**CAMPUS
IMPROVEMENT
PROGRAM 2014–2020**
STATE-SIGNIFICANT
DEVELOPMENT
APPLICATION (SSD 13_6123)
JUNE 2014

**1.
RESPONSE TO
SUBMISSIONS**

The University of Sydney has reviewed all submissions received during the statutory public exhibition period and the extended (non-statutory) public consultation period of State Significant Application *SSD 13_6123 The University of Sydney Campus Improvement Program 2014-2020 for Camperdown-Darlington Campus*.

01 ENGINEERING - PROPOSED ENVELOPE PLAN

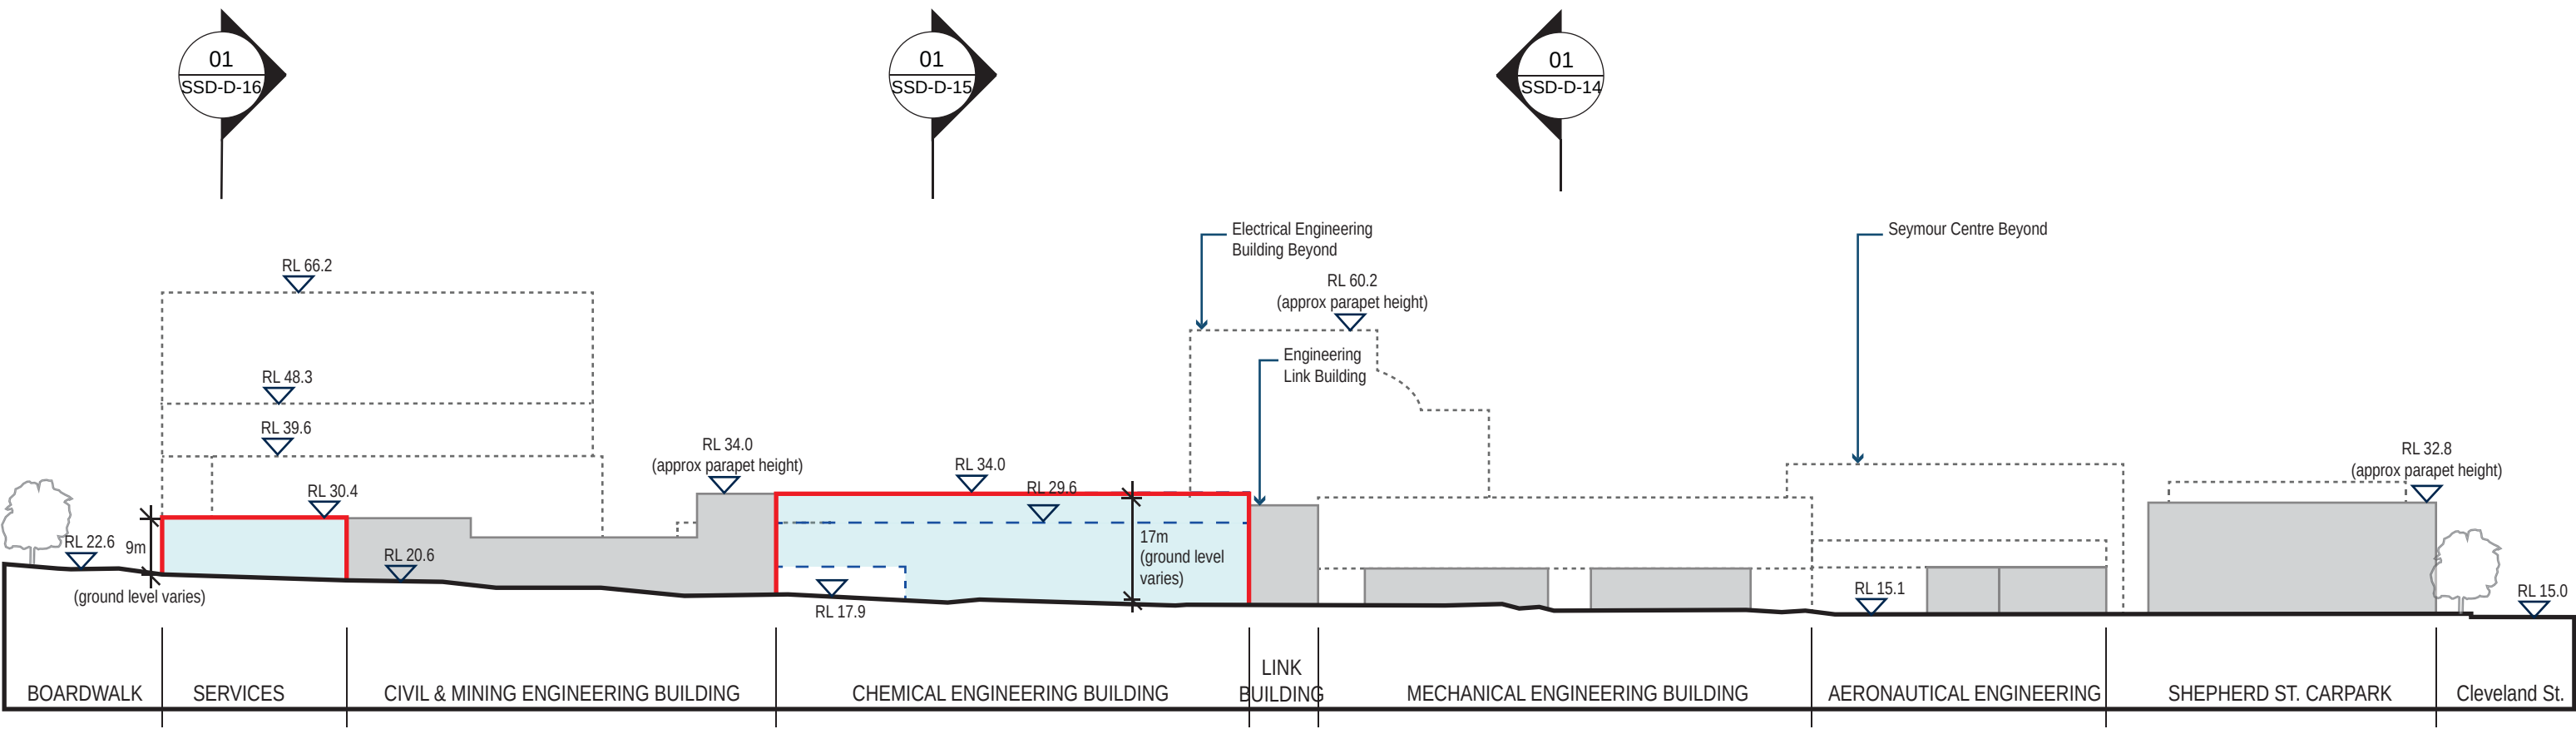
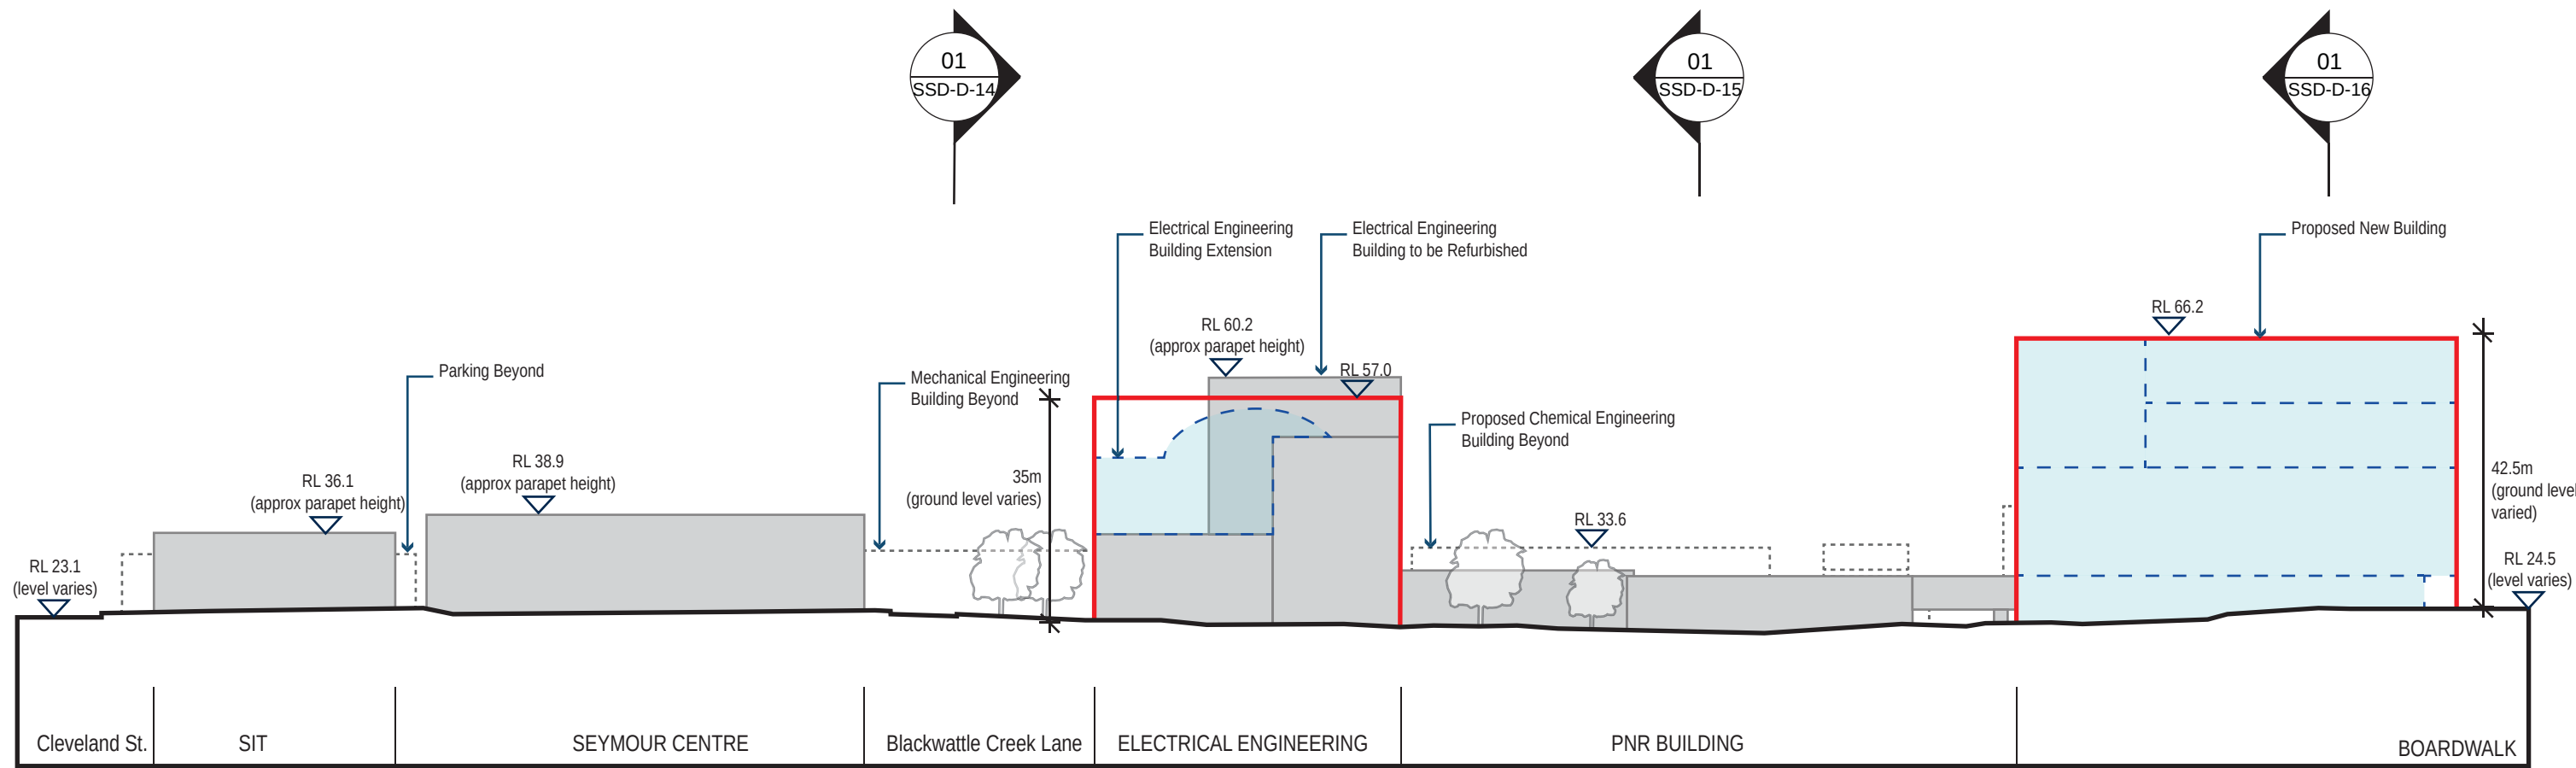
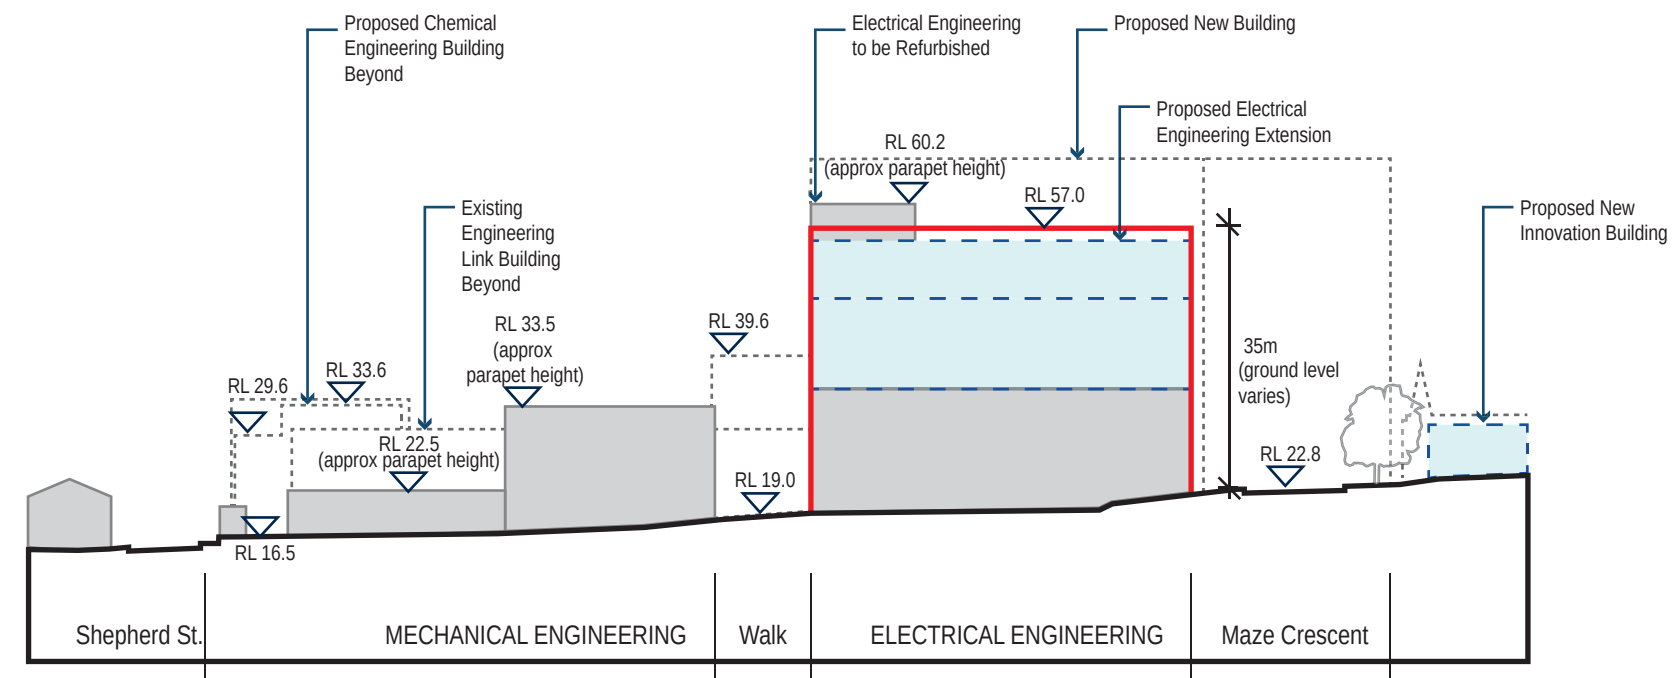
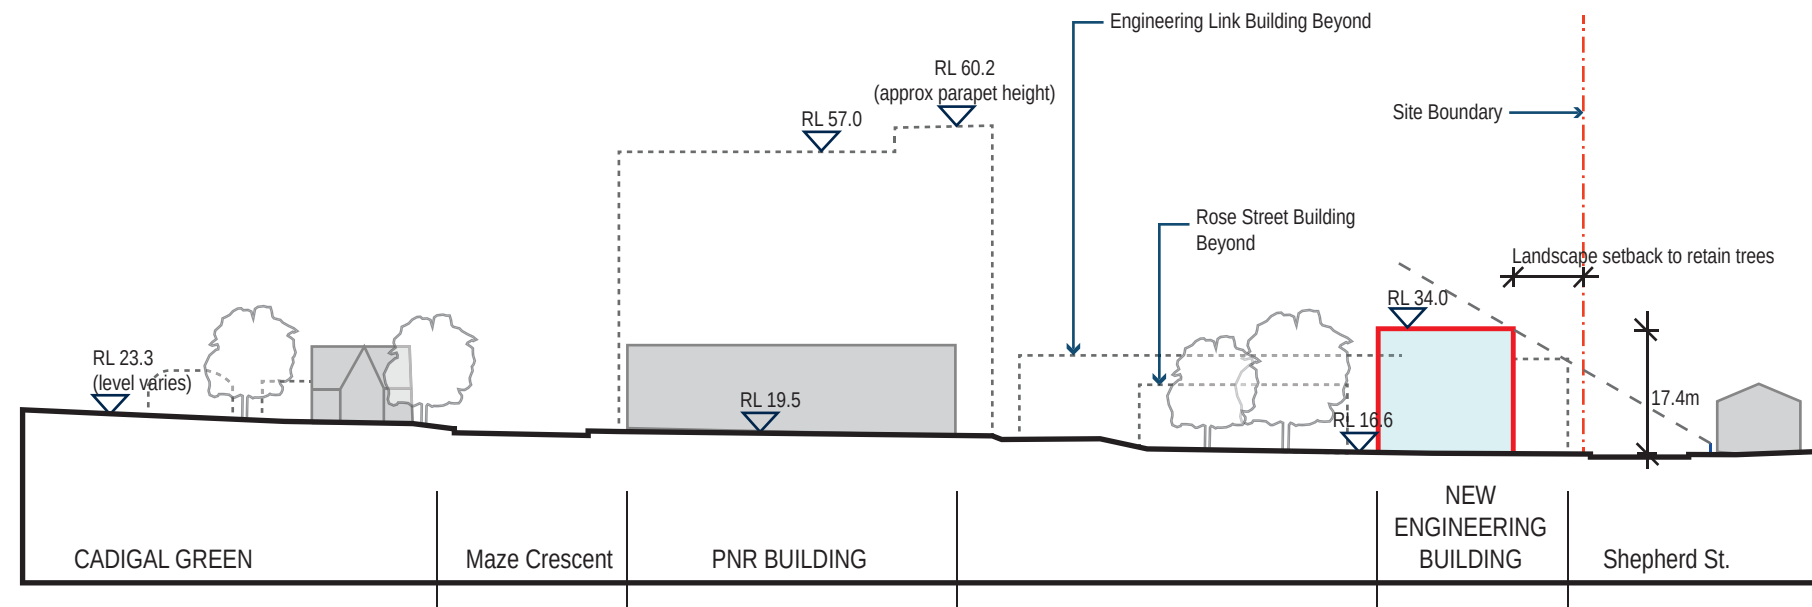
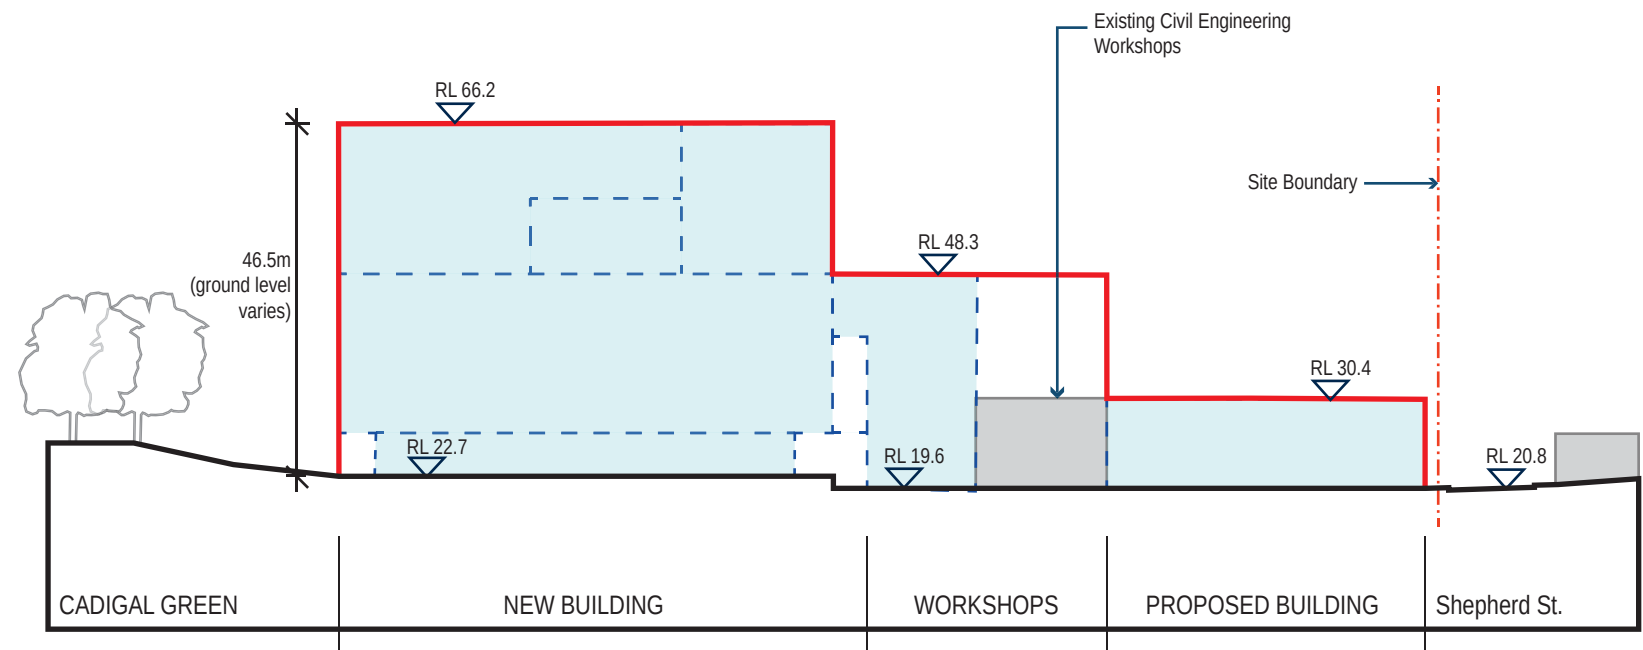
| ISSUE | CIP RESPONSE |
|--|--|
| <p>13. PROPOSED ENGINEERING BUILDING (SHEPHERD STREET SITE)</p> <ul style="list-style-type: none"> • The building will increase overshadowing on Shepherd and Calder Streets. • The unusual geographical lie of the land finds Calder Road Terraces from no.'s 57-67 facing this site almost directly. The existing two to three story Civil Engineering Building fronting Shepherd Street already shadows terraces from 67 Calder to 153 Shepherd Street in winter. • The building will create additional noise through its use. • The building will also significantly reduce the visual amenity of Shepherd Street. • The proposed building height is much higher than the houses opposite and this will further reinforce the fortress like quality of the University. • This building will bring pollution. • This building will bring crime. • This building will do nothing good to the aesthetics of the area. • The University should look at other sites. • Building façade being 3 storeys will impinge on my privacy as it will be a direct line of sight into my backyard. • The building will block my already limited sunlight into my backyard. • The building will be populated with people who will drive to work. Currently parking is unobtainable due to University Students. • The building will bring visual pollution. • The building will do nothing but harm flora and fauna. | <p>The revised CIP Engineering Precinct building envelope and Shadow Analysis reveals that additional mid-winter shadows will fall upon the Shepherd Street carriageway from noon onwards. Additional shadows will be cast upon the dwelling facades of 54 Calder and 146 Shepherd Street between 2:30 and 3:00pm. However, no additional afternoon shadows are created to the rear yards of Shepherd and Calder Street dwellings as these are already caused by existing boundary walls and fences. The revised CIP envelope for Engineering reduces the projected additional shadows (compared to the original CIP) as a consequence of building envelope setbacks.</p> <p>The CIP has been prepared to deliver the systematic refurbishment and redevelopment of the existing Engineering precinct which is proposed to deliver world class teaching, learning and research facilities over time.</p> <p>The Engineering faculty is pursuing a program of upgrading old building mechanical and other equipment to meet appropriate regulatory requirements for acoustic performance.</p> <p>Further specific and detailed buildings will be subject to future detailed Application or other approval pathways and will be generally consistent with the Stage 1 CIP SSD consent.</p> <p>The CIP Engineering Precinct is located wholly on University land and within a precinct that has historically been limited to the Engineering faculty.</p> <p>The Engineering building will be subject to a future detailed Application and the issues raised in the submissions relating to shadowing, privacy, noise impacts, pollution etc. will be addressed through that process.</p> |

| ISSUE | CIP RESPONSE |
|---|---|
| <ul style="list-style-type: none"> • Why not build the building on the large grassed area on Cadigal Green. • Queries the possibility of opening up a vista from Shepherd Street to Cadigal Green as the planned building will prevent it. • Construction of a building in the current eucalypt grove and car park will increase ground temperatures on the surrounding streets and contribute to overshadowing on Shepherd Street. • The construction of this building close to the road would also cause homes to be overlooked by windows day and night and create light and noise pollution with air conditioning at night. • Objects to the proposed 3 storey building in Shepherd Street and the “multi-disciplinary” building opposite the Sports Centre both of which will overlook resident’s homes in Shepherd St, Calder Rd, Lander St, Boundary Rd and Abercrombie St. | <p>The CIP proposes to remove vehicle car parking from the Engineering Rose Street car park and relocate this to campus peripheral parking locations. The CIP Access Strategy aims to reduce unnecessary vehicle access to campus and to increase use of public transport and active (walking and cycle) modes of transport.</p> <p>Both the existing and revised CIP Engineering building envelope provides a clear pedestrian entry and connection opposite Calder Street, and through to the Engineering Rose Street courtyard and Cadigal Green beyond.</p> <p>Both the existing and revised CIP Engineering building envelopes provide a setback of 16-20 metres from the 4 residential Shepherd Street dwellings opposite the Rose Street car park site. The building envelope site is not intended for student accommodation but for teaching and learning facilities during University daytime hours. The proposed distance is satisfactory to mitigate privacy invasion.</p> |
